**CITY OF ALBUQUERQUE
PLANNING DEPARTMENT
February 22, 2012
DRB Comments**

**CITY OF ALBUQUERQUE
PLANNING DEPARTMENT
May 30, 2012
DRB Comments**

APPLICATION # 12-70151

RE: Tract A-1-B-1, Los Angeles Center

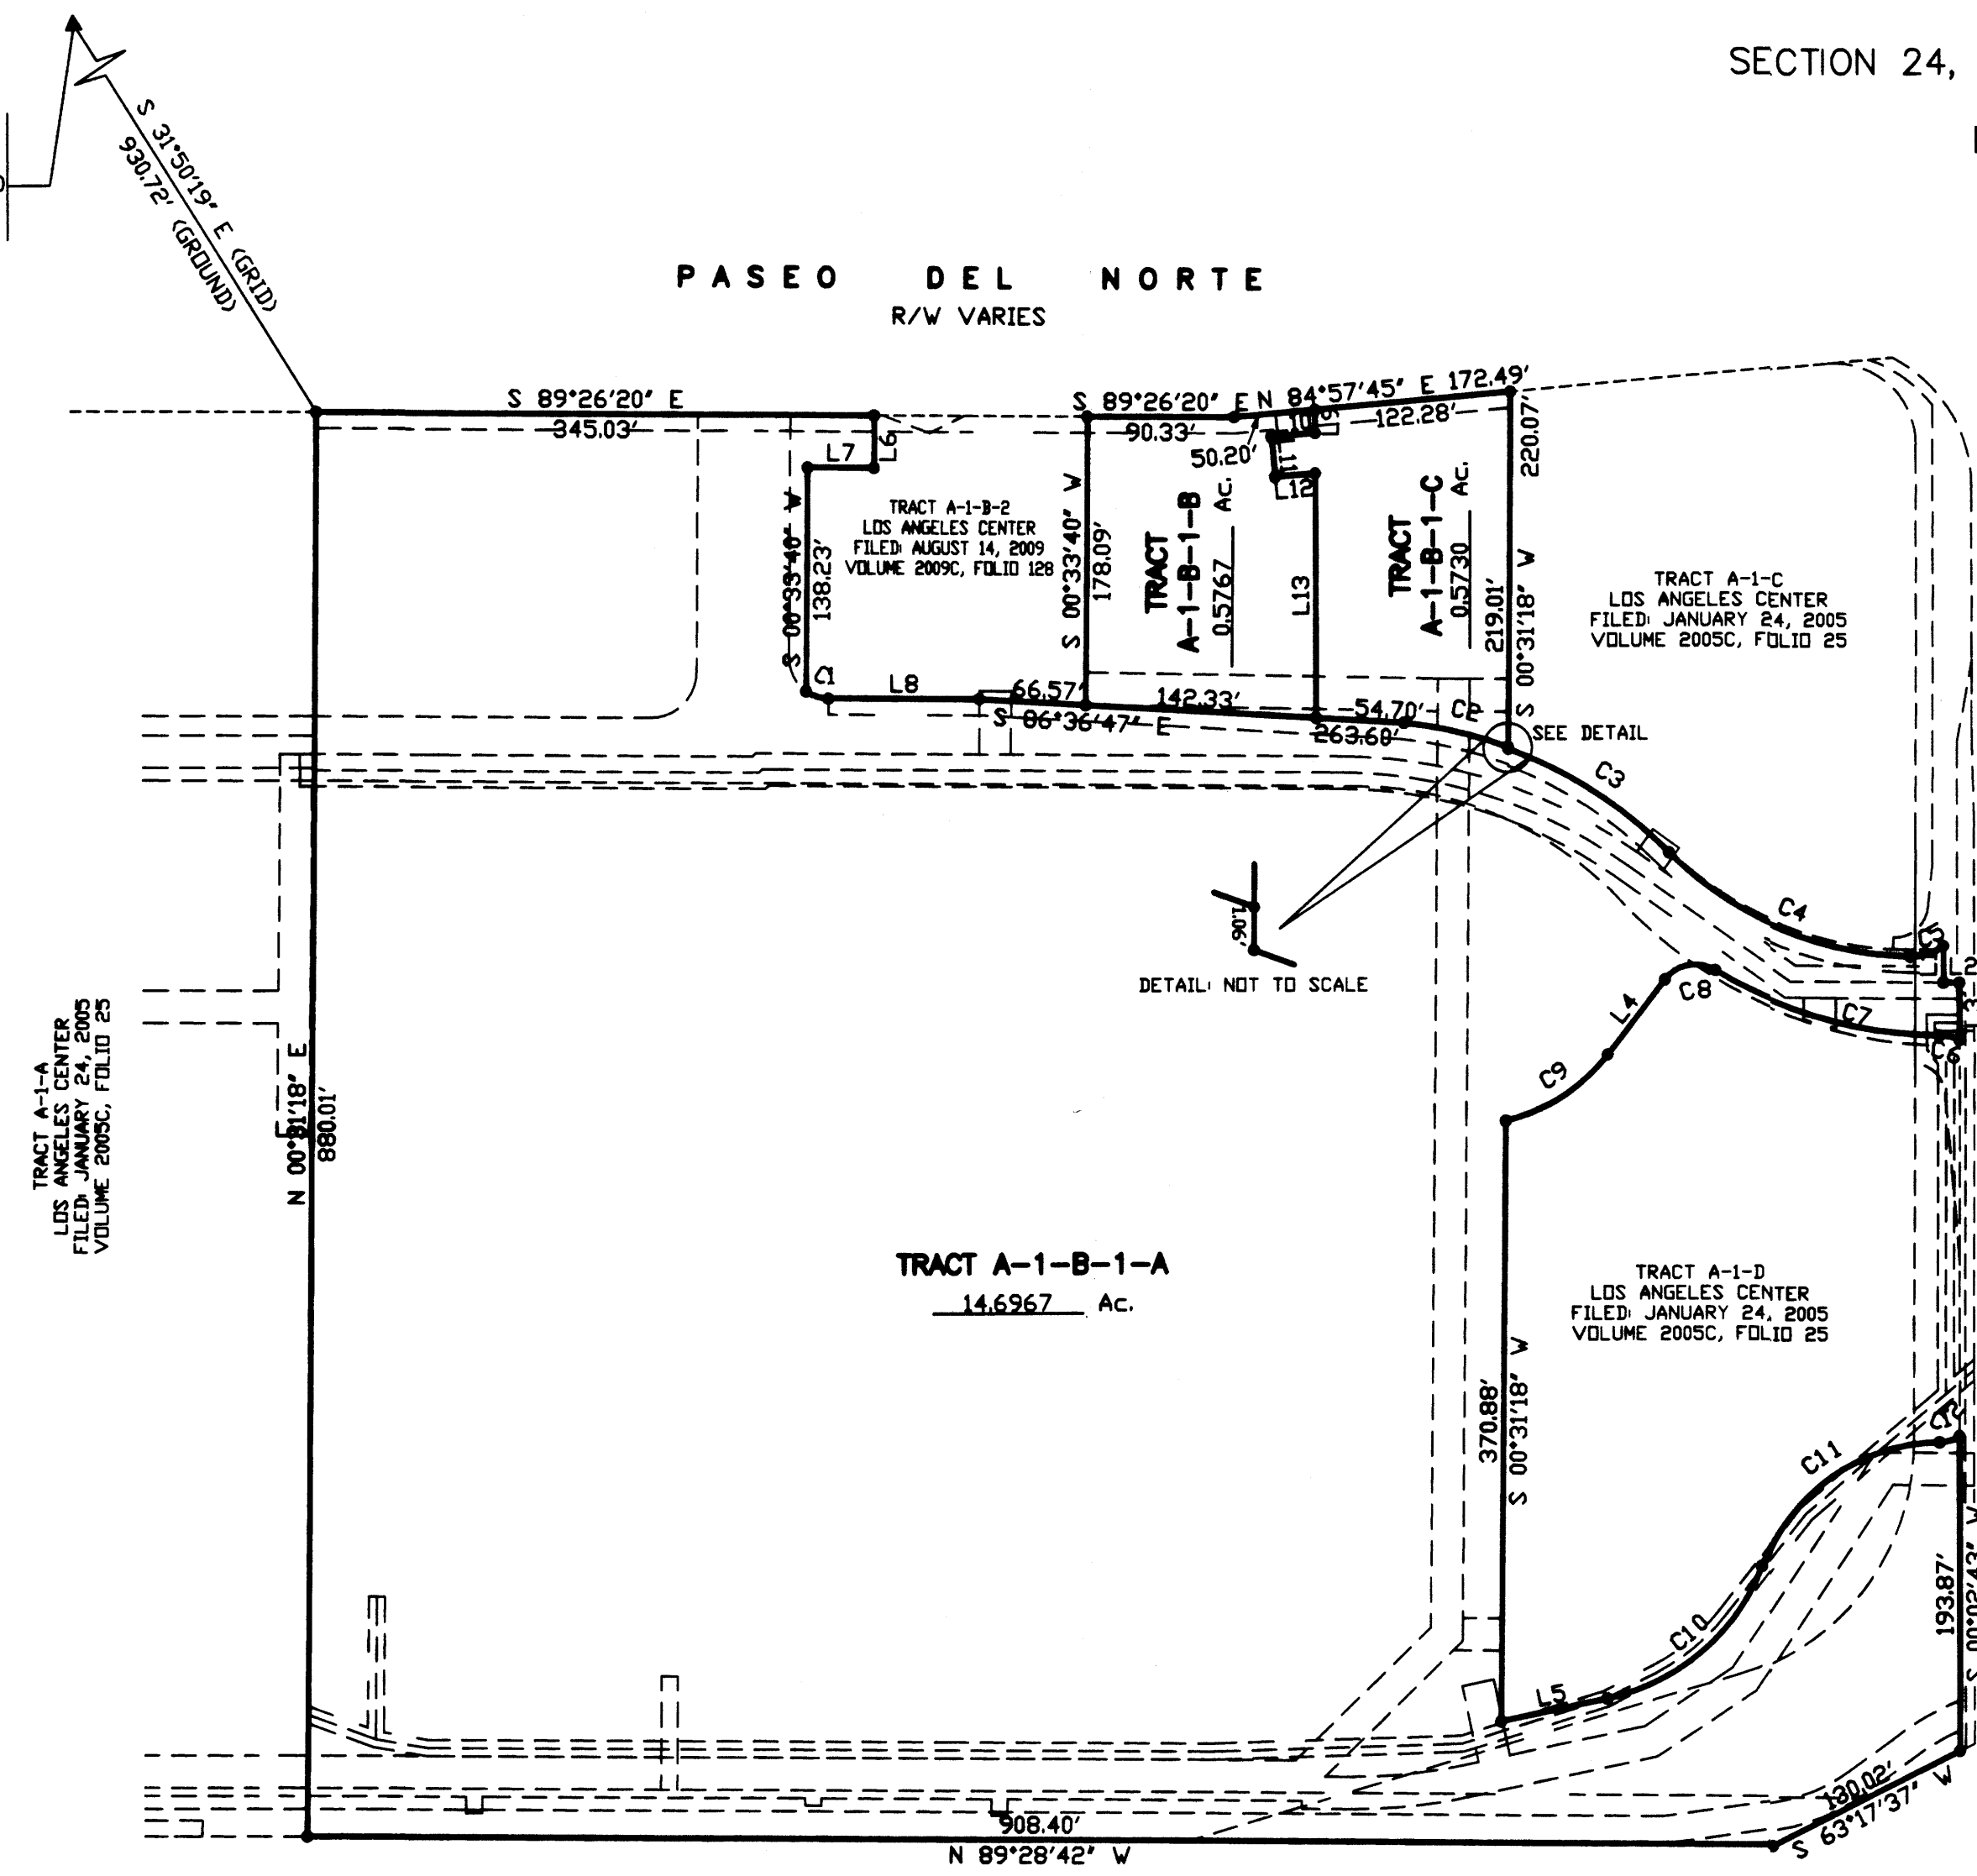
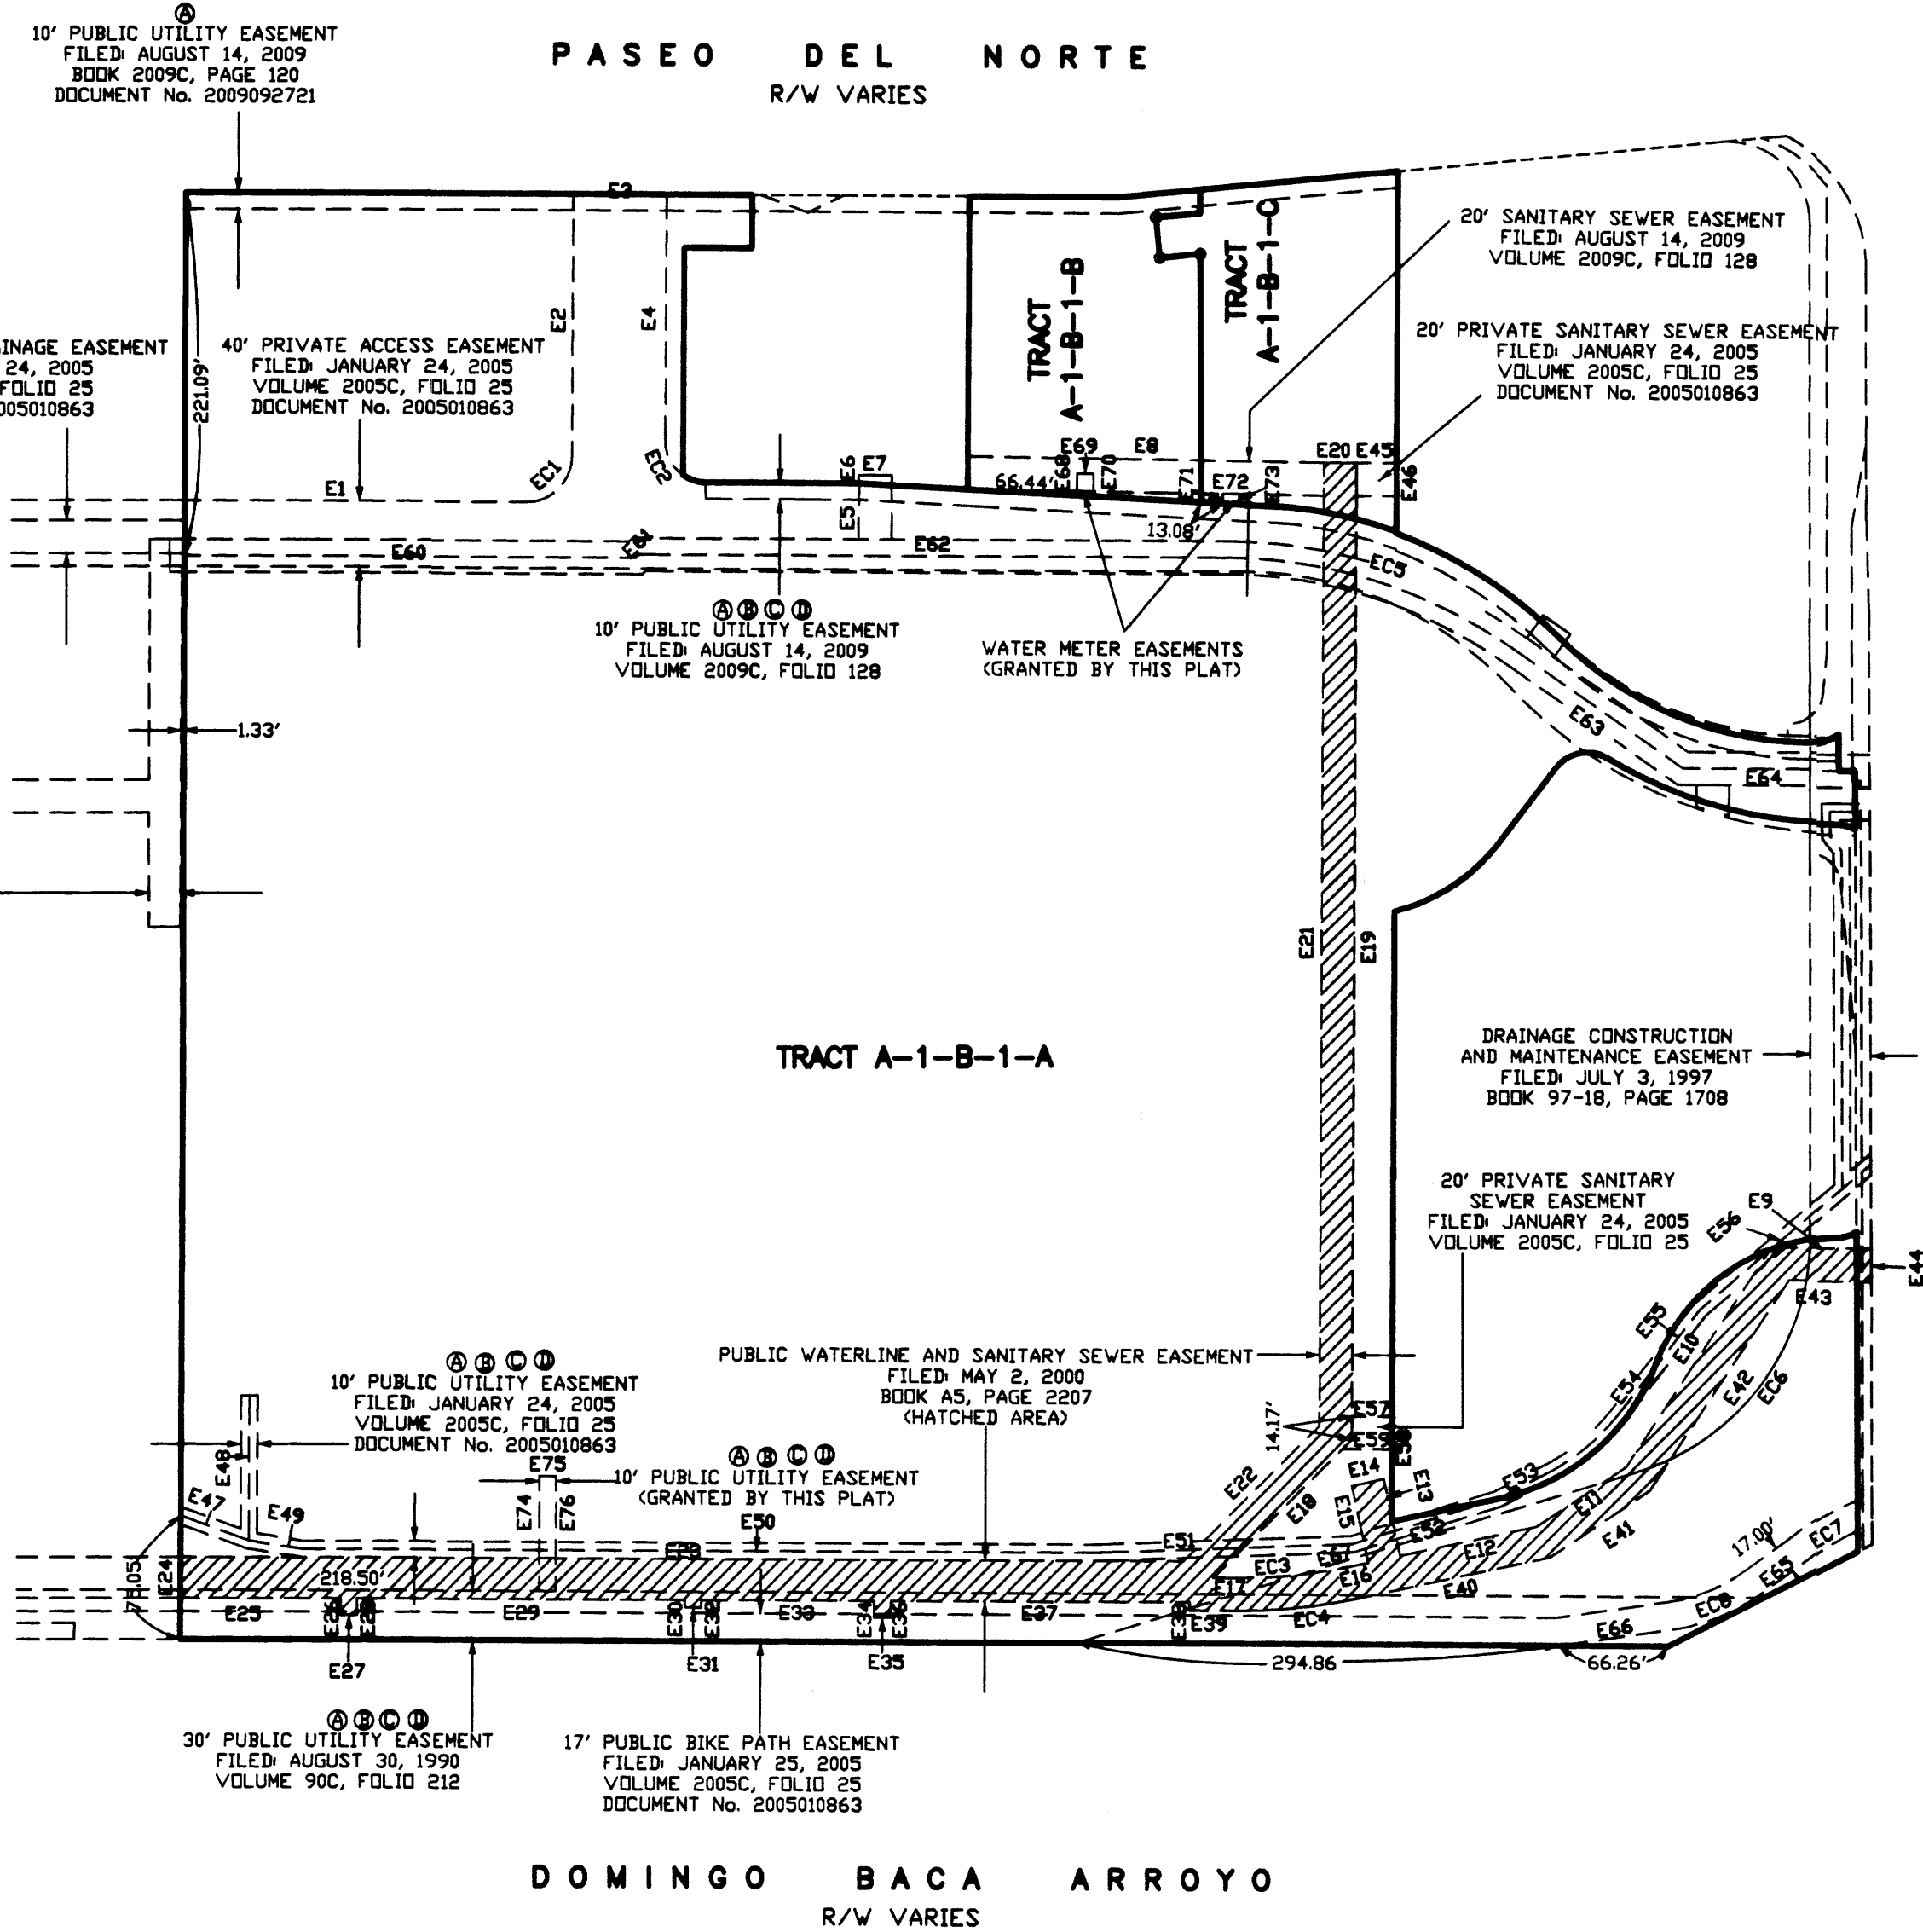
PLANNING (Last to sign): correct /ie notes L to E

The proposed Note 10 is not consistent with the previous note required by § 14-14-4-7(B) of the Subdivision Ordinance; any additional note regarding restriction of solar collectors must be consistent with § 14-14-4-7(C) of the ordinance. Design standards of the approved site development plans may be referenced.

SITE PLAN FOR SUBDIVISION - REQUIRED INFORMATION

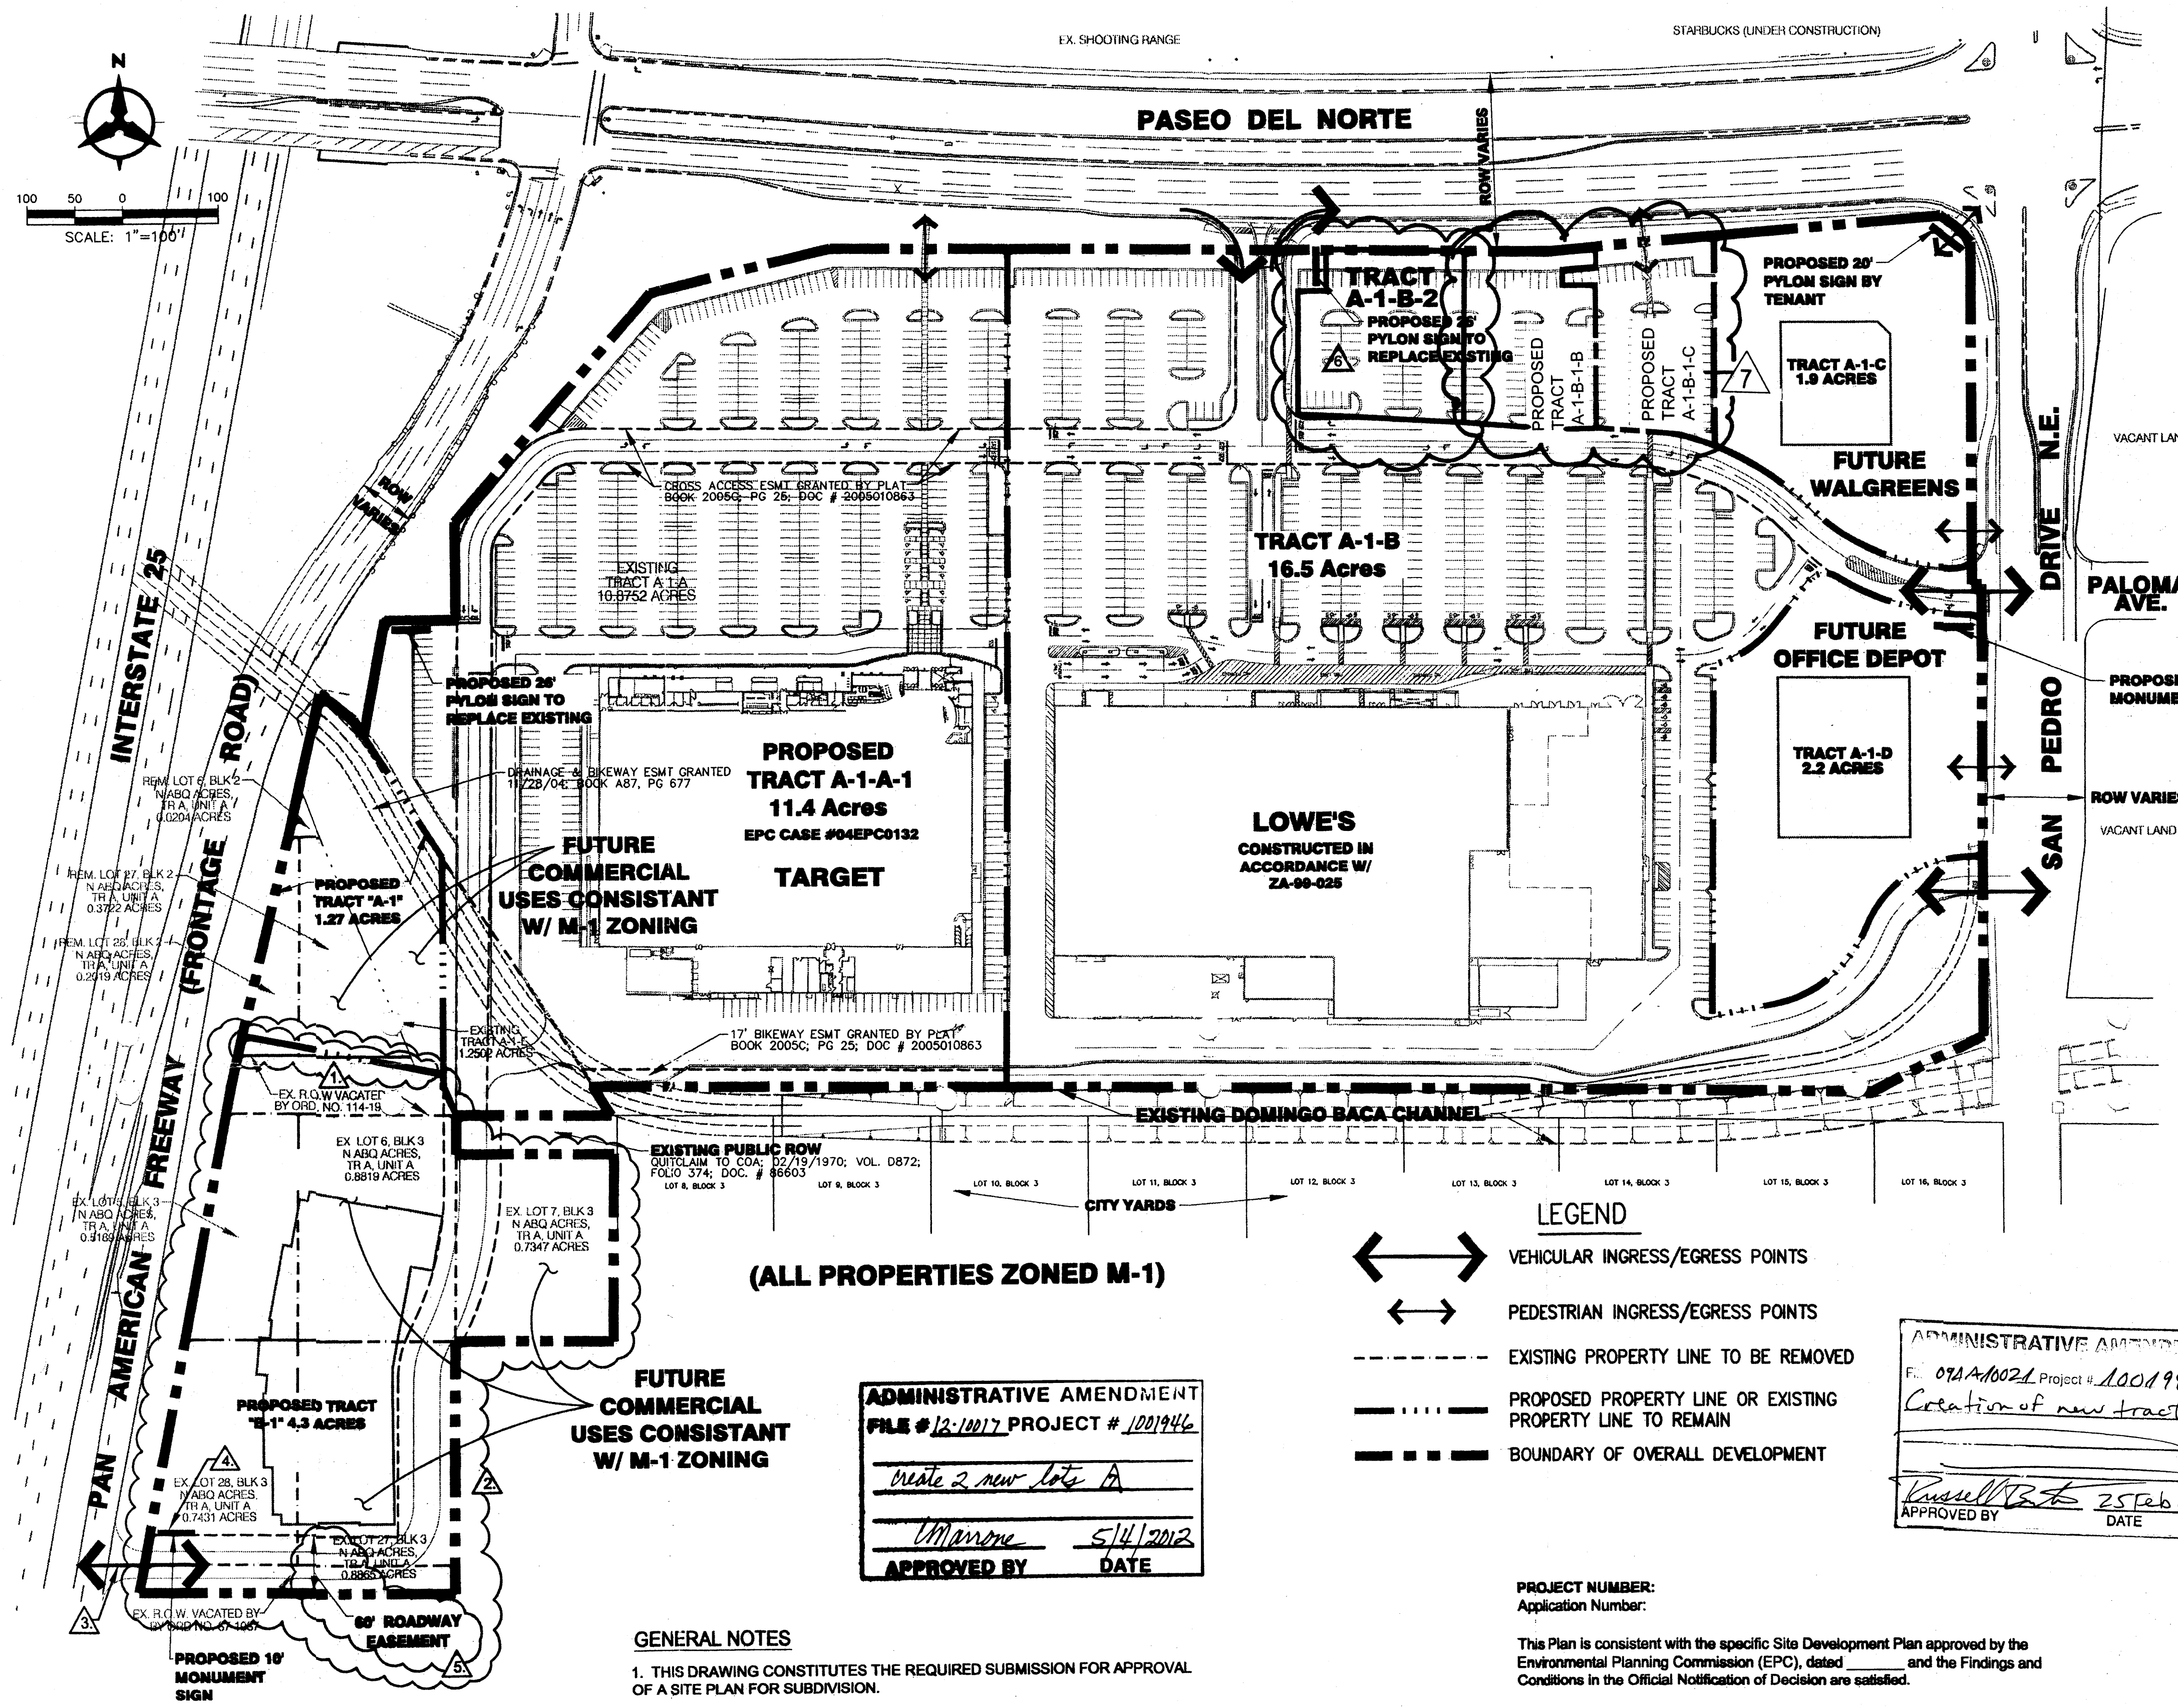
The proposed new lots do not appear suitable for subdivision based on the required parking for Lowe's as well as the pedestrian connection to Paseo del Norte.

Based on plans for improvement to the I-25/ Paseo del Norte interchange there may be significant impacts to this site regarding right of way, therefore this would be considered a significant amendment to The Site Plan for Subdivision and would require approval of the Planning Commission per the General Notes of the referenced site plan.
